From: Simon Davis
Sent: 23 February 2018 11:21
To: Planning.Responses
Subject: FW: St Josephs & Essex House BR/341/17/PL

Environmental Health

- Having reviewed the updated acoustic report in association with the amended plans EH would request that the mitigation measures in paragraph 7 of noise report 7726/AA-R Rev 4, 8 Jan 2018 be included in any conditions should planning permission be granted. This is in addition to the existing conditions relating to noise already set in the previous application.

St Joseph's, Bognor Regis
 Site Plan Showing Elevations Which Require
 Sealed Windows

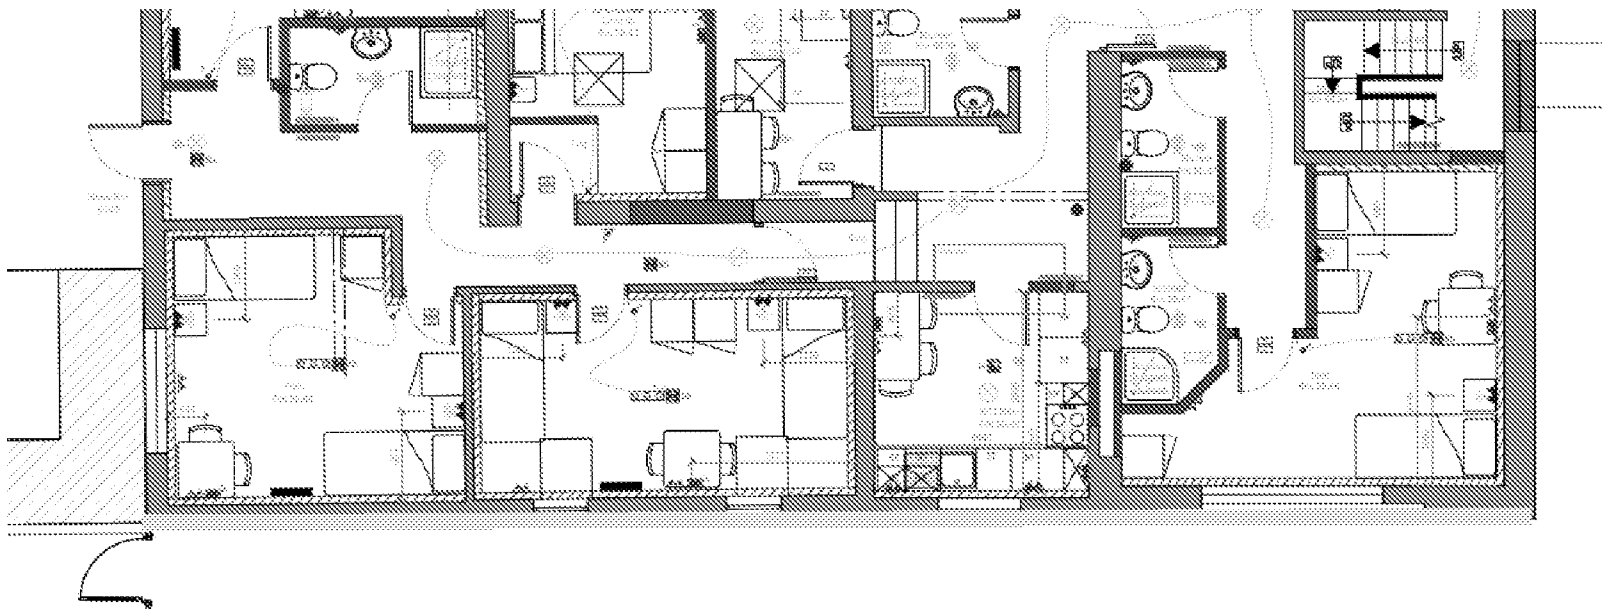
- The Acoustic Assessment Report in Section 7 identifies that all windows and roof lights to rooms should be sealed shut to prevent potential disturbance from noise breakout to Las Arenas. Mechanical ventilation can be accepted as an alternative in a kitchen however, is not suitable for a habitable room i.e. bedroom.
